16 June 2026

DEADLINE 4

**East Midlands Gateway Phase 2 – BC0410001 (the DCO Application)
Application by SEGRO Properties Limited in respect of a Business and Commercial development comprising a second phase of the SEGRO Logistics Park East Midlands Gateway and highway related development (EMG2)**

**East Midlands Gateway Phase 1 Material Change Order – TR0510002 (the MCO Application)
Application by SEGRO (EMG) Limited for a material change to the East Midlands Gateway Rail Freight Interchange and Highways Order 2016 (SI 2016/17)**

Highway Plans CROSS SECTIONS SHEET 2 OF 3

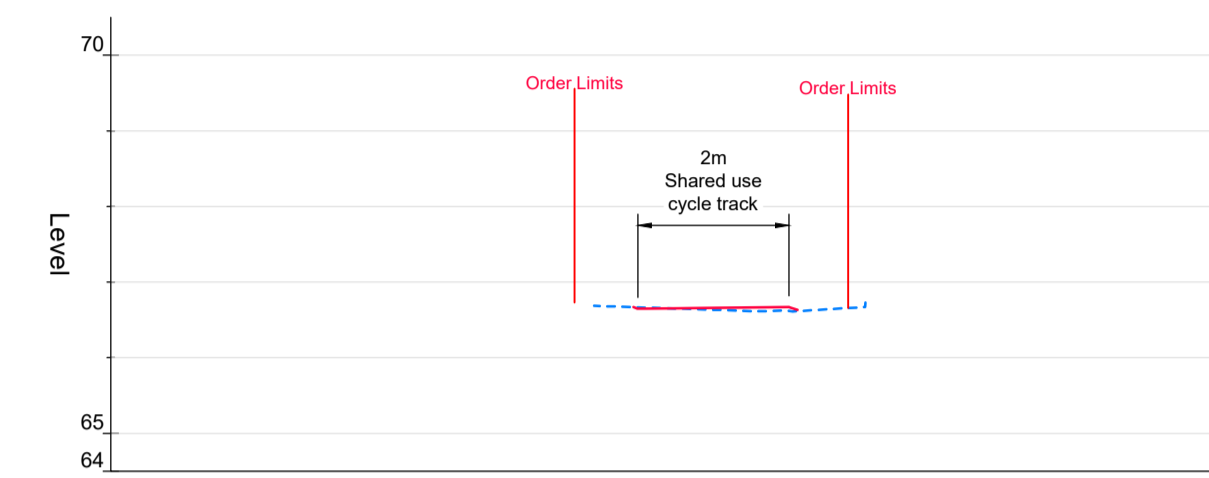
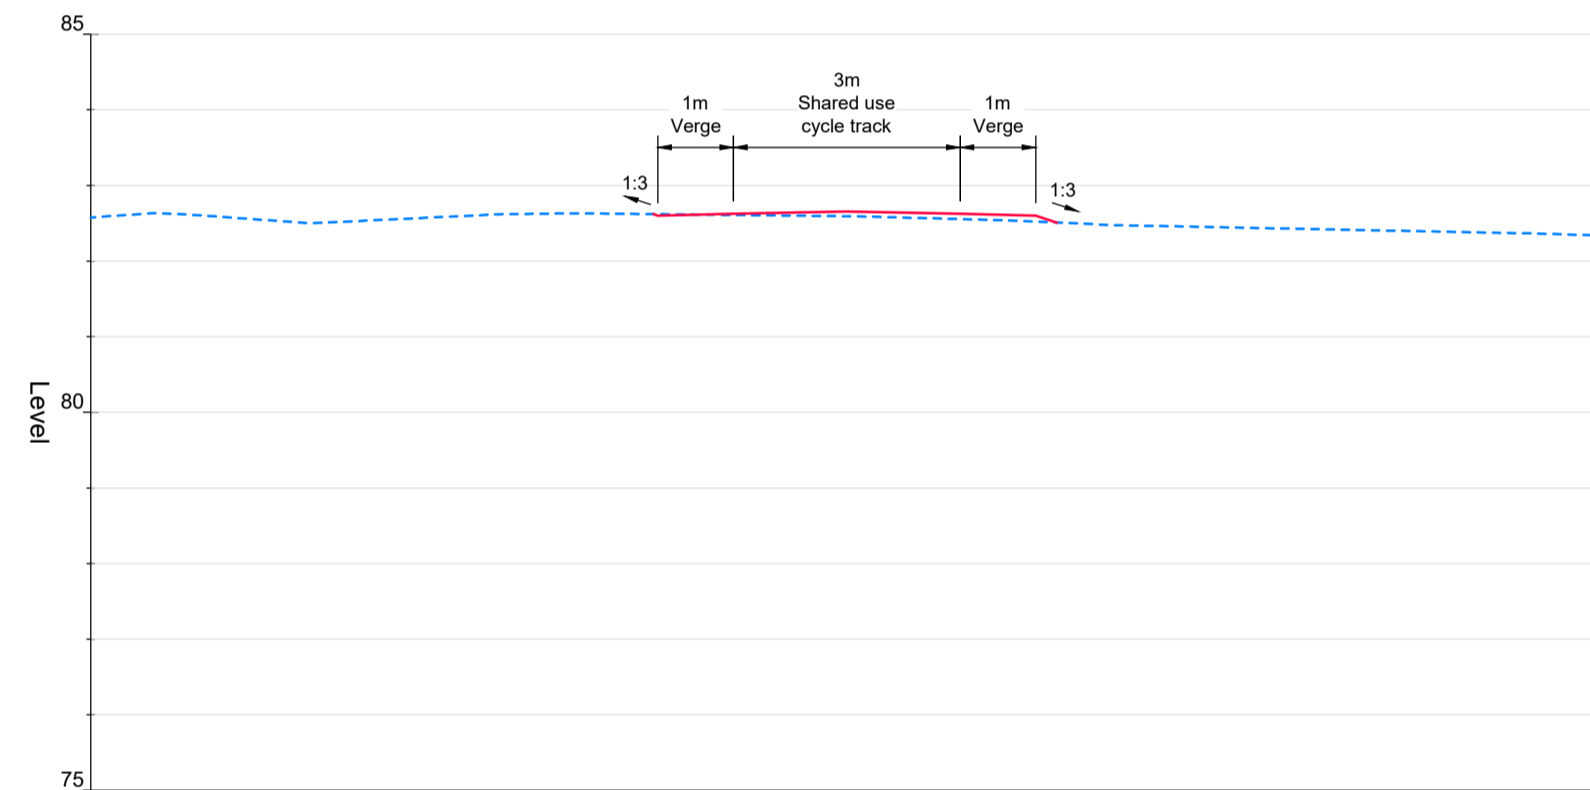
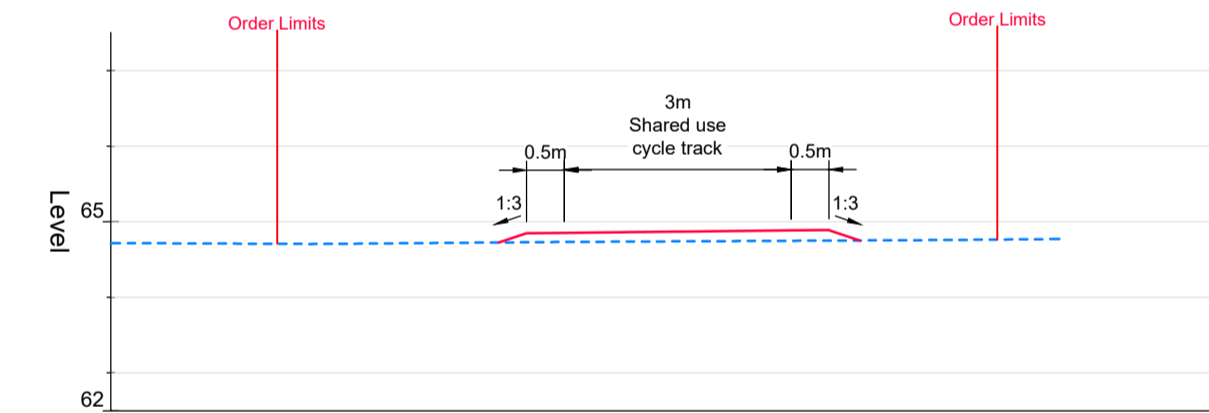
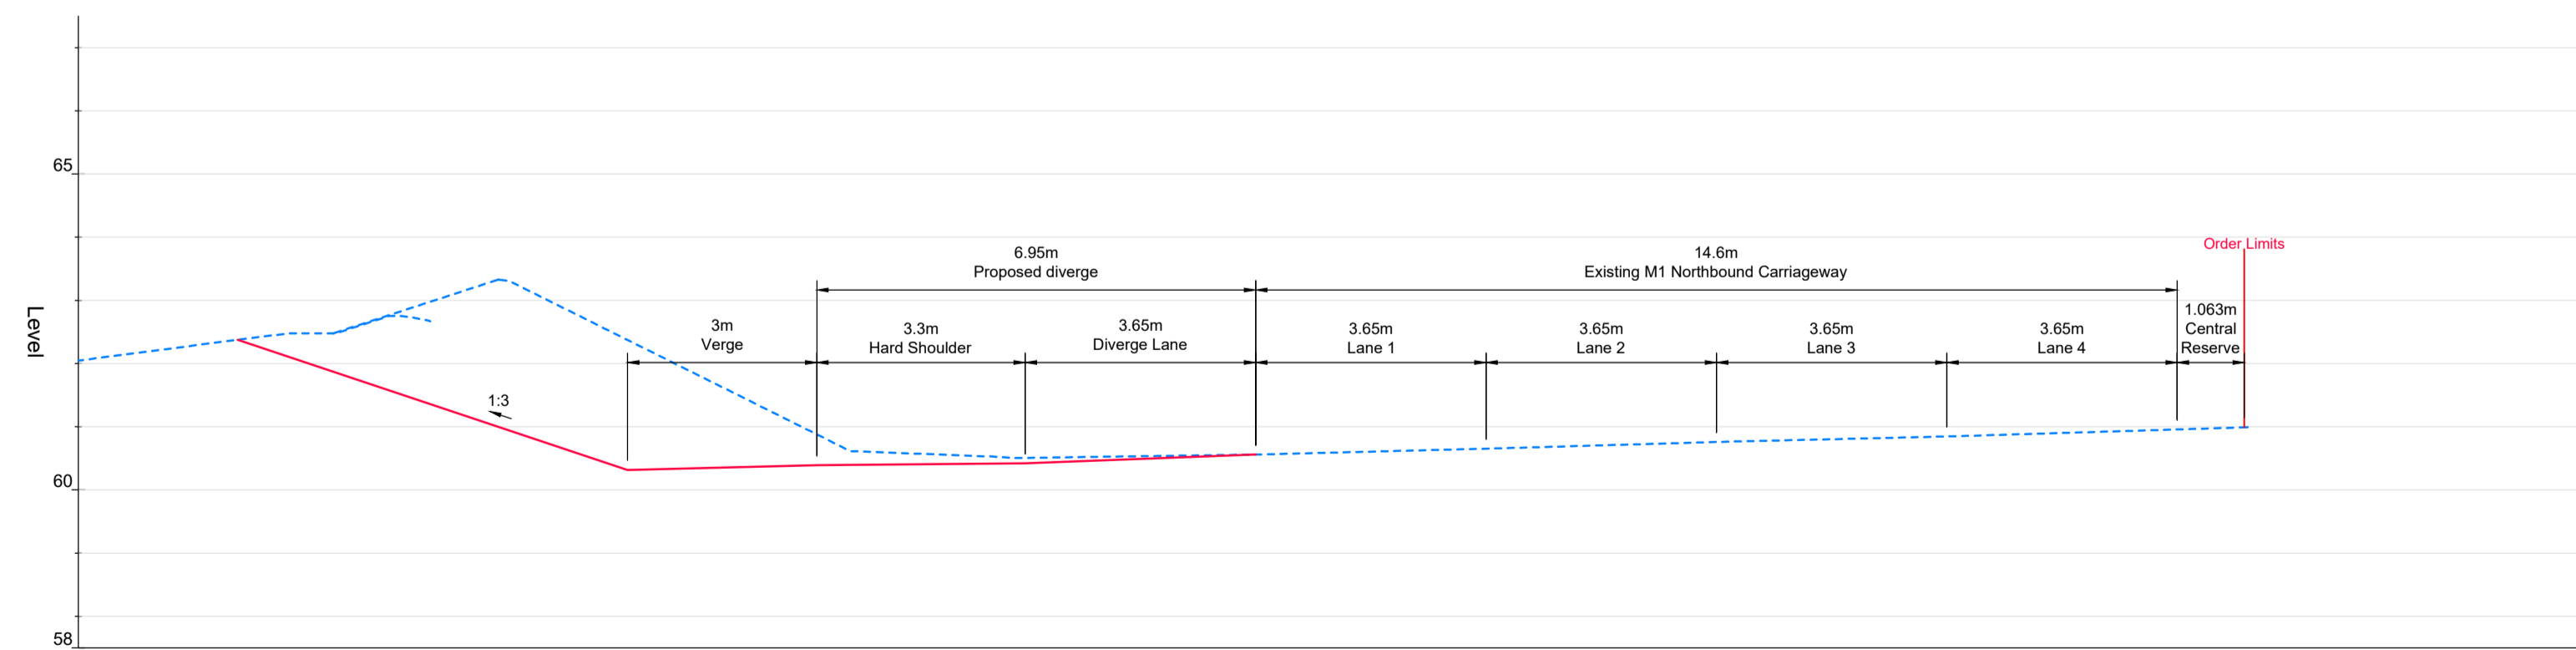
| Document Name | Doc. Ref. | Explanation |
|---|----------------------------|---|
| Highway Plans Cross Sections Sheet 2 | DCO 2.9B [REP1-019D] | Amendment to reflect the revised alignment of the ATL |

Drawing Title
HIGHWAY PLANS LONG SECTIONS SHEET 3 ACTIVE TRAVEL LINK, L57 FOOTPATH UPGRADE AND EMG2 ACCESS

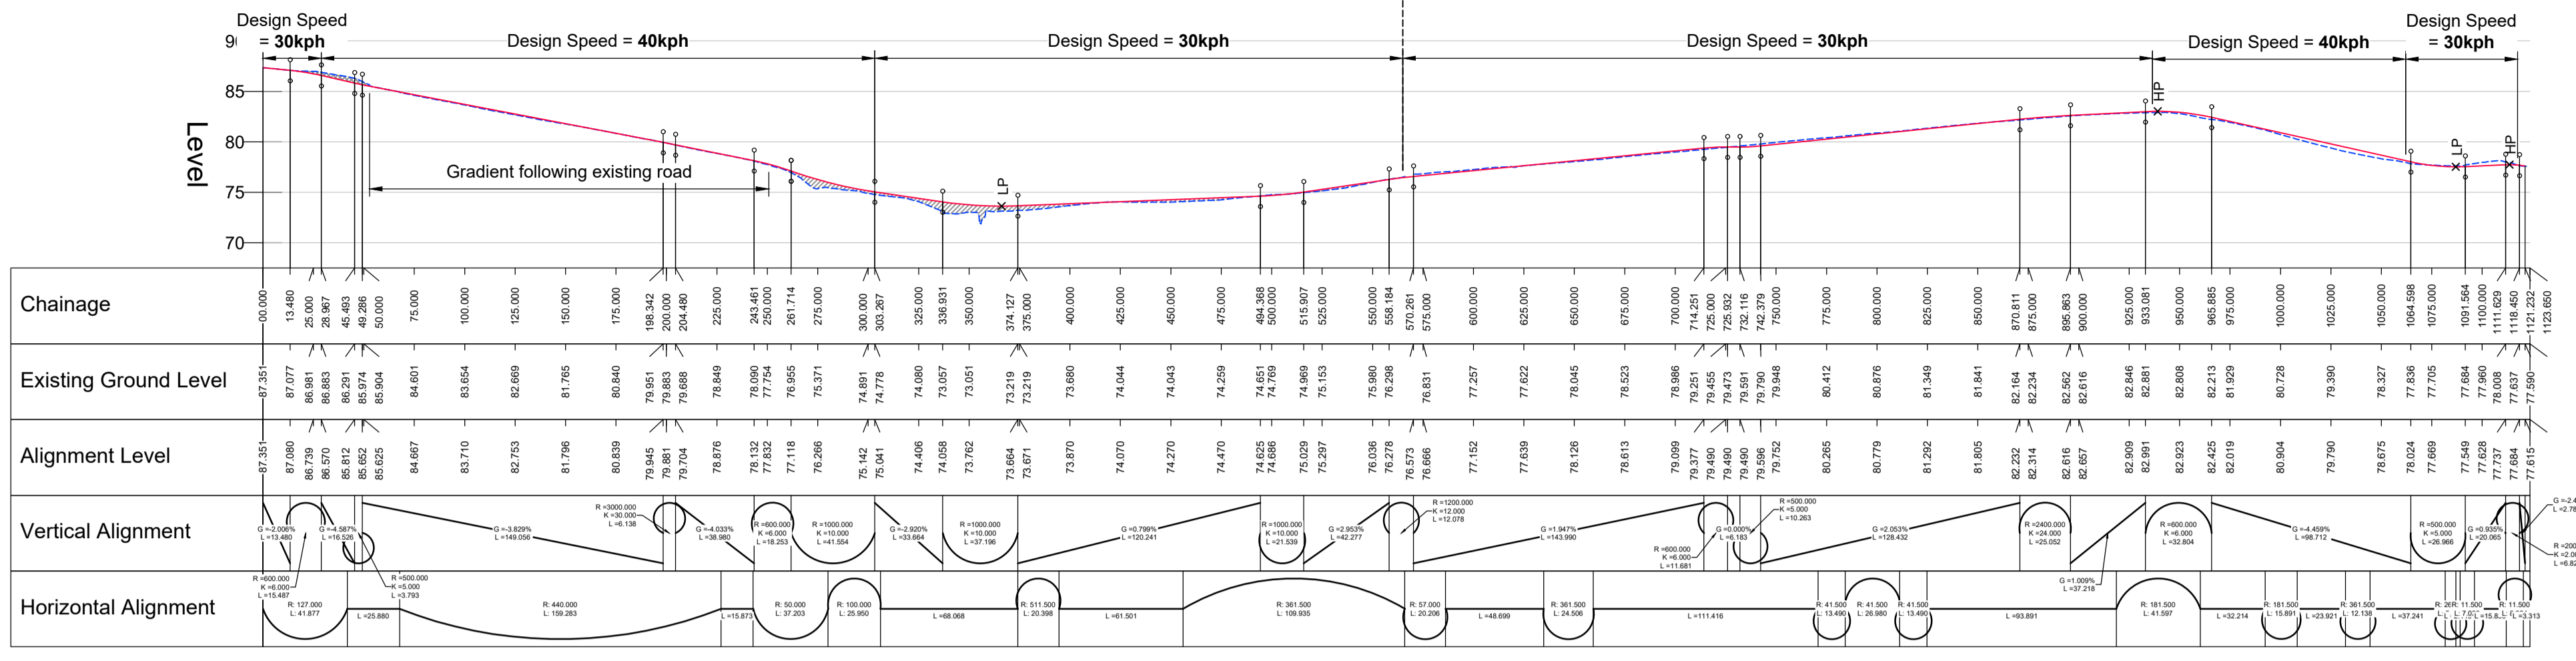
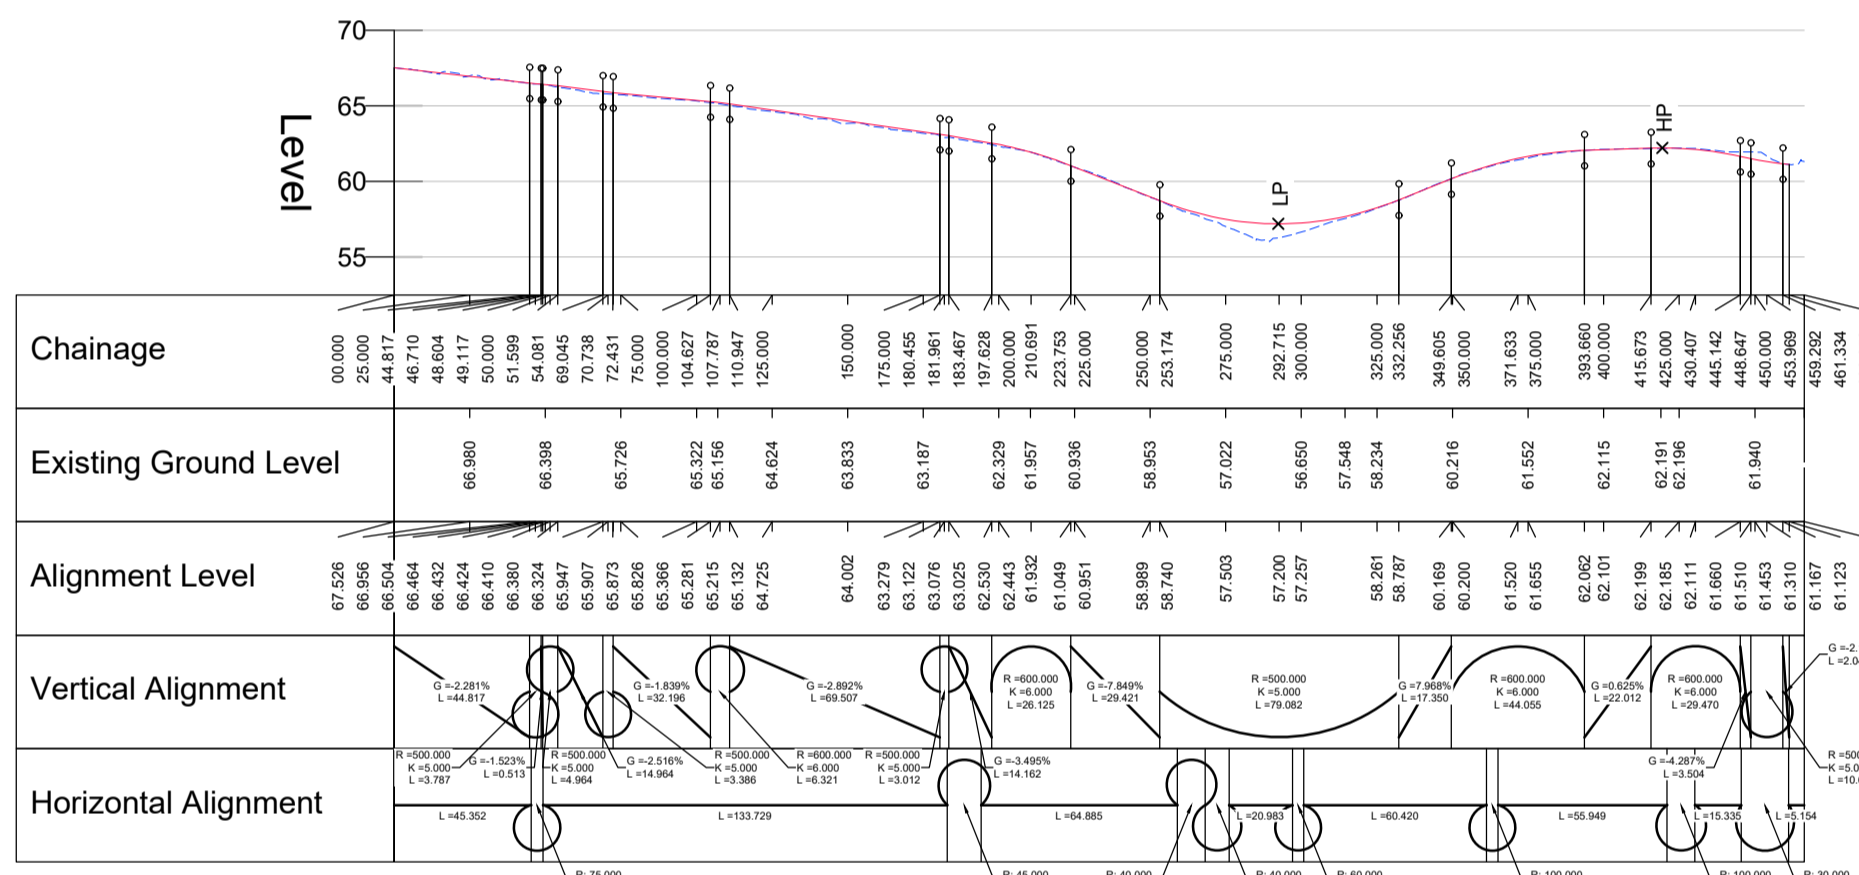
| Document Name | Doc. Ref. | Explanation |
|---|----------------------------|---|
| Highway Plans Long Sections Sheet 3 | DCO 2.10C [APP-051D] | Amendment to reflect the revised alignment of the ATL |
